Subject: **Blind Creek Solar Farm (SSD-13166280) – Environmental Impact Statement (EIS)**

Detailed advice to DPE Planning & Assessment regarding the Blind Creek Solar Farm (SSD-13166280)

Figure 8: Extract from Pre-Development 1% AEP Flood Velocity Map showing Velocity Vectors (note erroneous mapping of the watercourse)

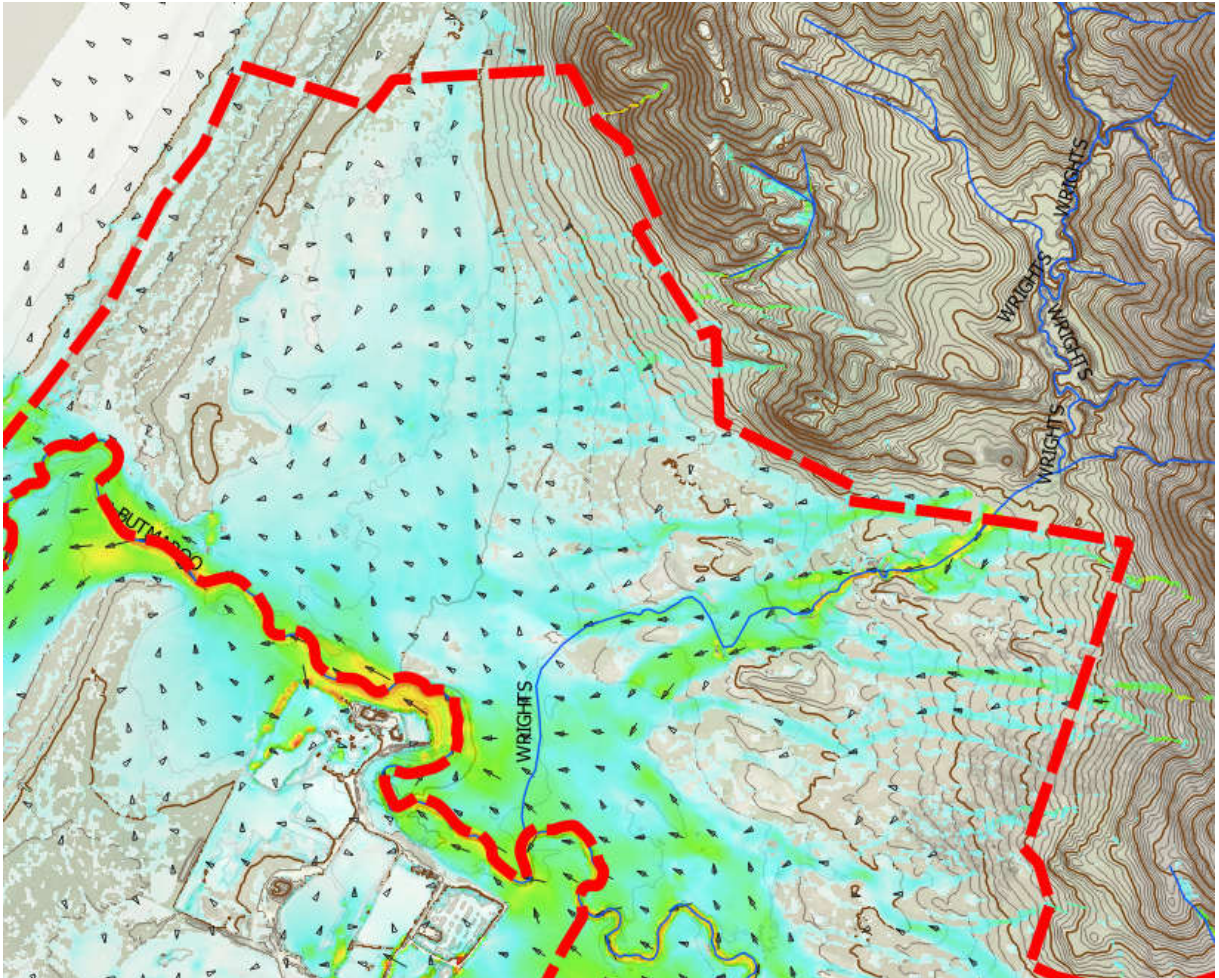
- Provide a flow path for Wrights Creek which does not contain solar arrays.
- Confirm setbacks have been planned in accordance with the Guidelines for Controlled Activities on Waterfront Land (NRAR 2018).

- DPE Water acknowledge that Wrights Creek is a defined creek upstream of the site but does not have a defined channel (bed/banks or vegetation changes) through the site. The site serves as a broad drainage path to Butmaroo Creek/Lake George. DPE Water recommends that a designated flow path which does not contain solar arrays be provided through the site to allow for an unimpeded path flow downstream. The width of the flow path should give due consideration to the Guidelines for Controlled Activities on Waterfront Land (NRAR 2018) as well as site merits.
